SUBJECT: Engineering Review Comment
Mountain View Electric Association Inc. (The Association)

Project Name: Walden Preserve 2 Filing 5 – Final Plat

Project Number: SF2211

WALDEN PRESERVE 2, FILING NO. 5
LOCATED IN THE E1/2 SEC. 15 AND IN THE SW1/4 SW1/4 SEC. 14
ALL IN T. 11 S., R. 66 W. OF THE 6th P.M., EL PASO COUNTY, COLORADO

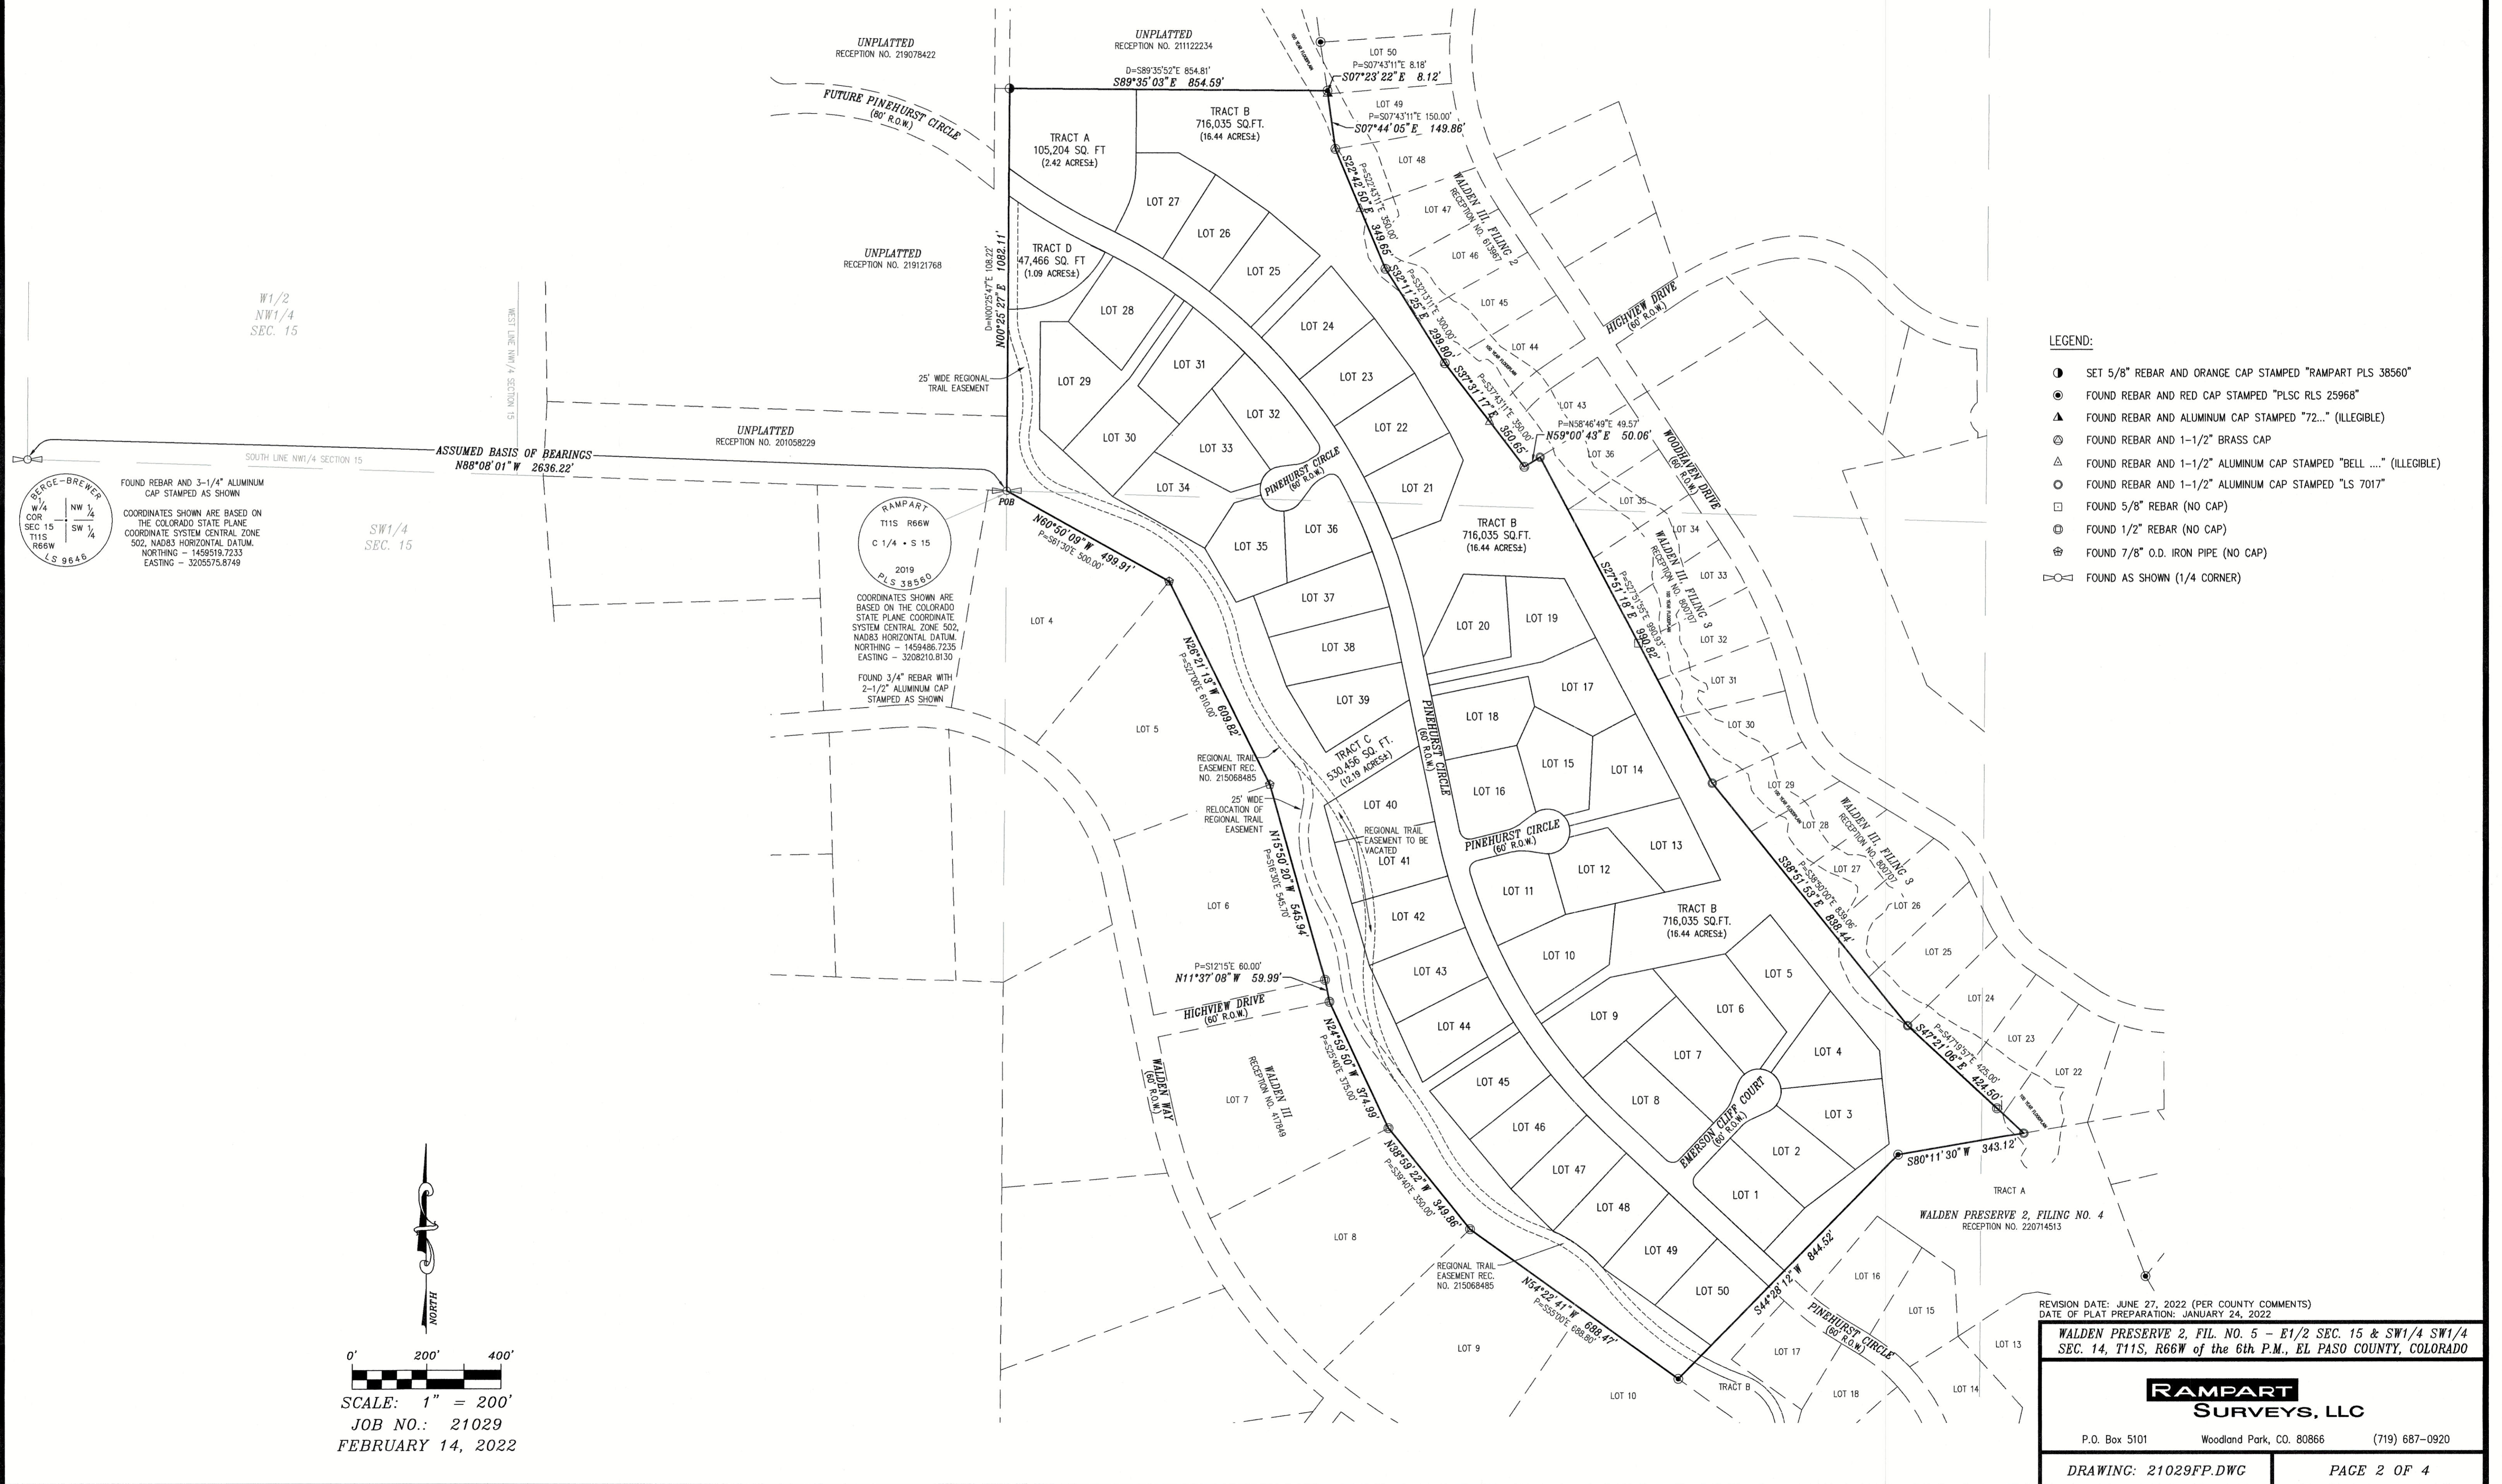
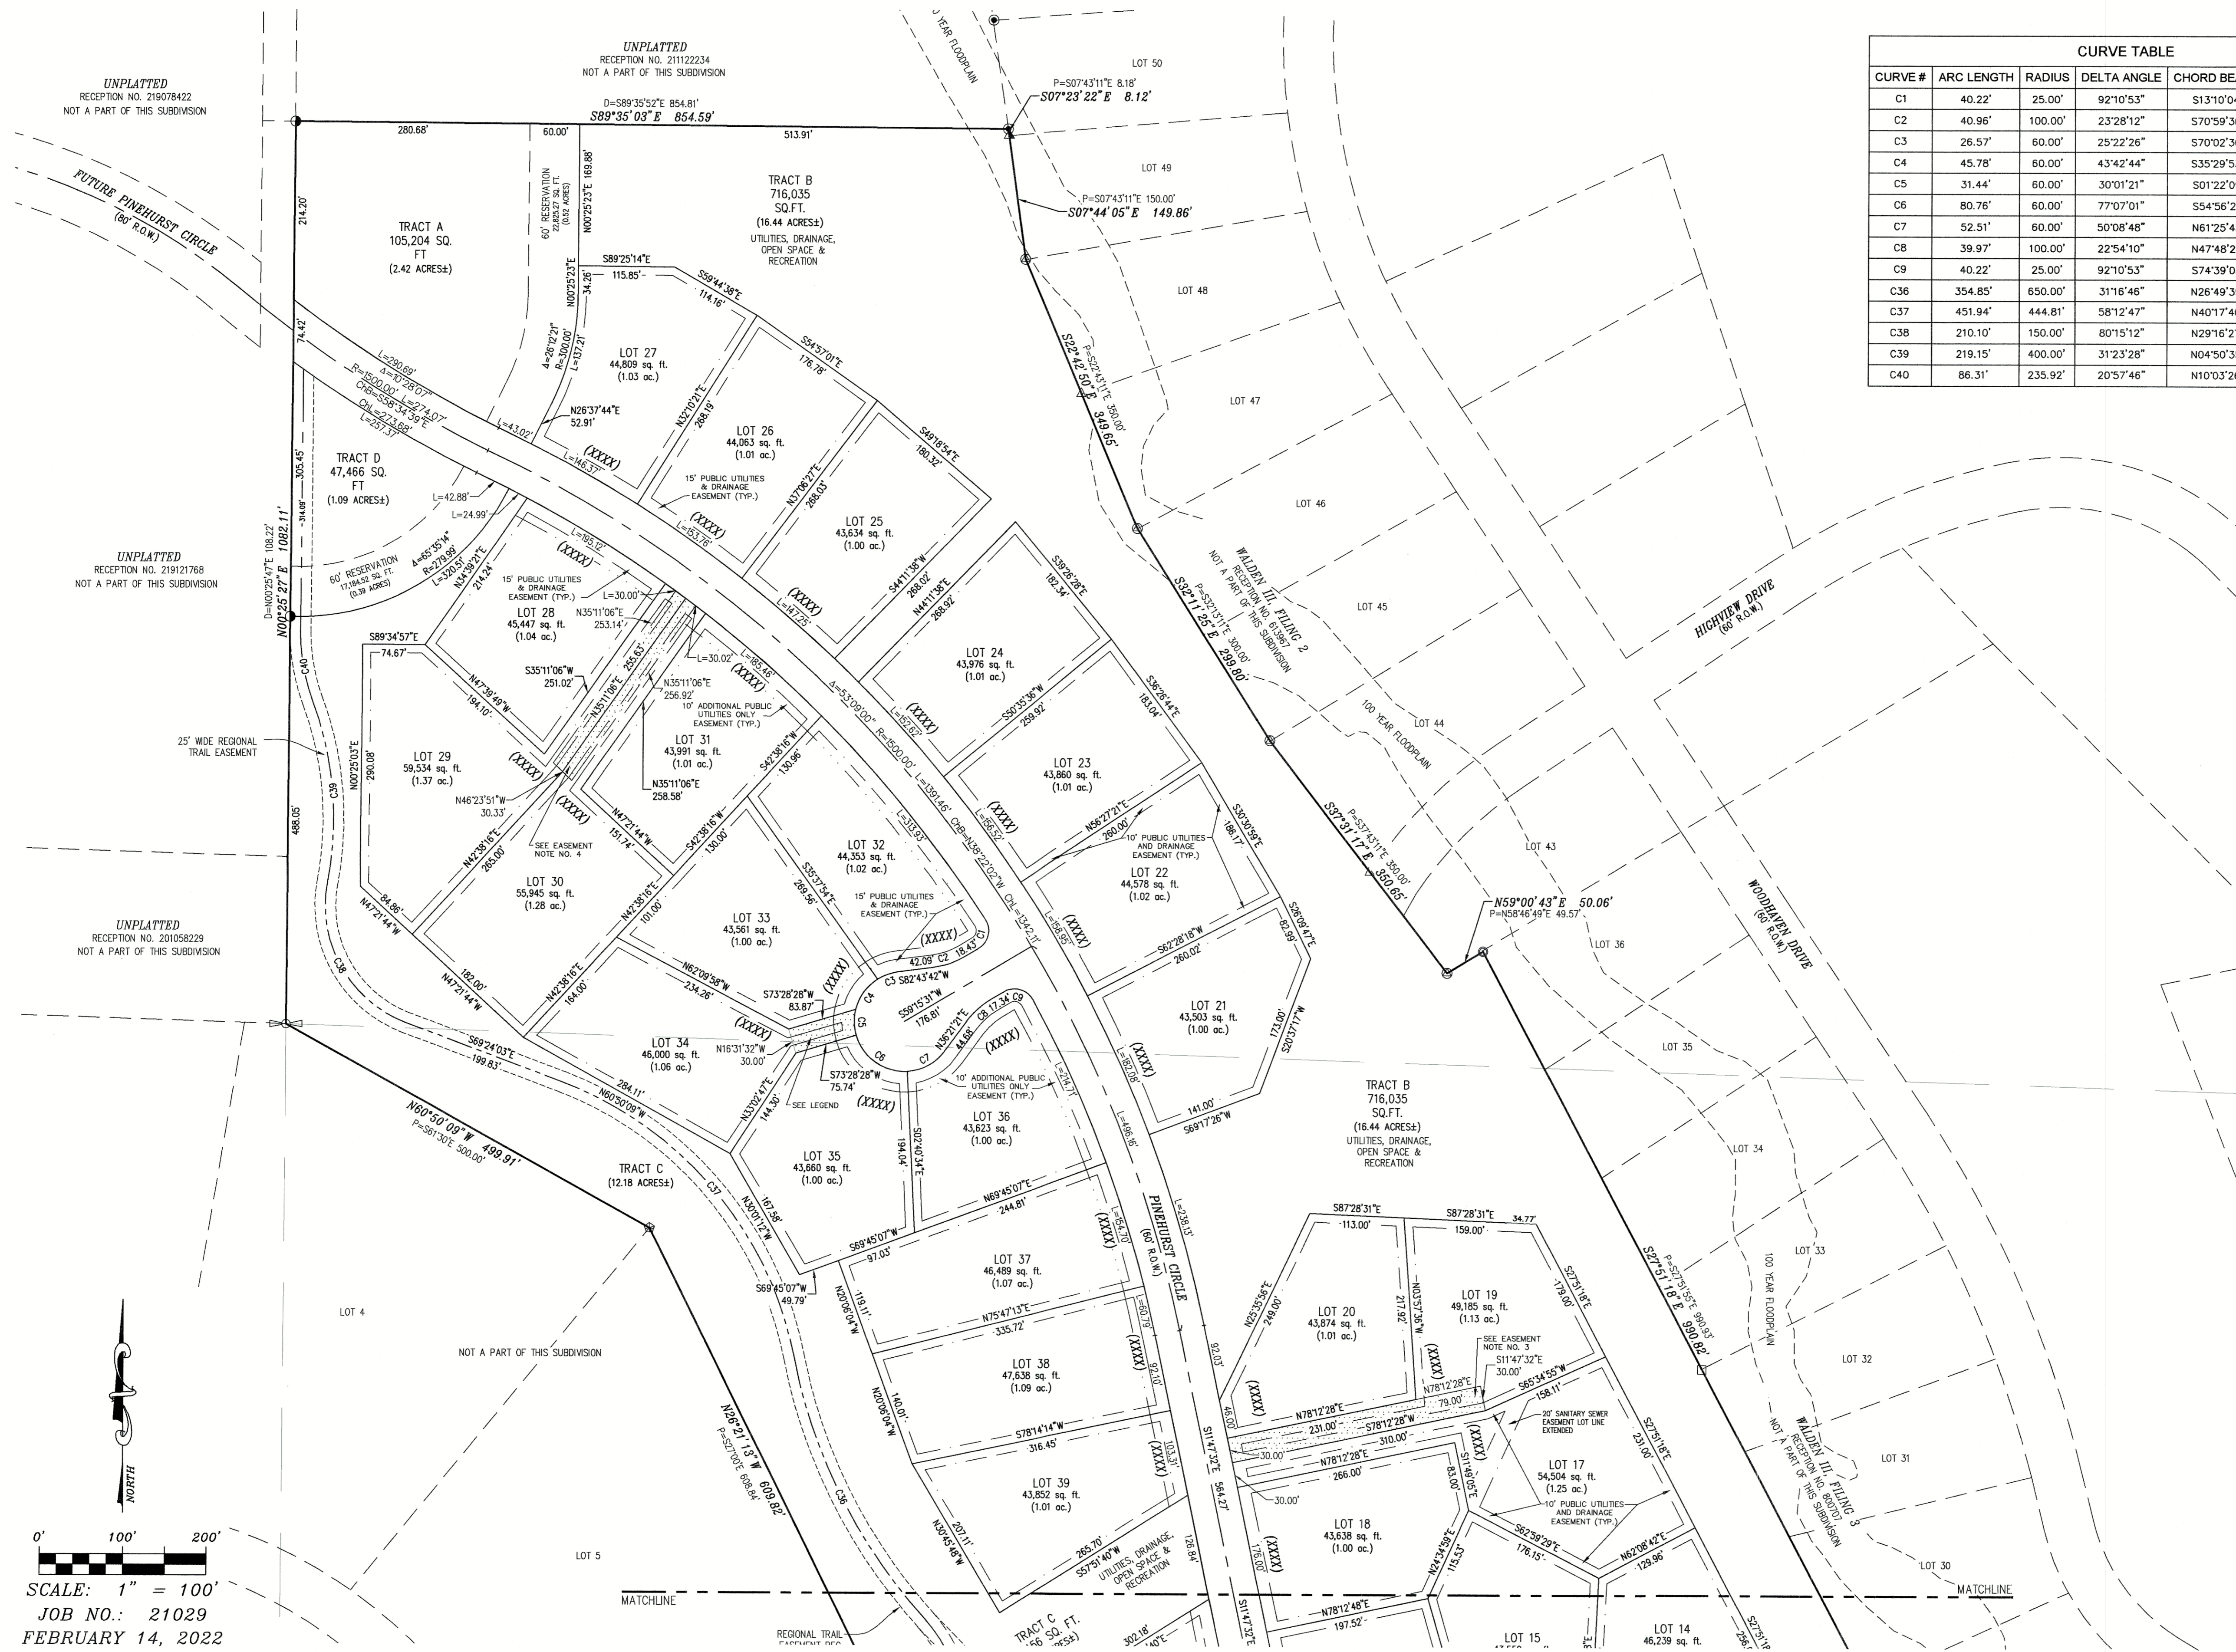
The Association requests a fifteen (15) foot front lot line utility easement and a ten (10) foot side, and rear lot utility easement on the plat and all tracts. The Association also requests the platting of the Association's existing facilities with easements on the plat. Additional easements may be required.
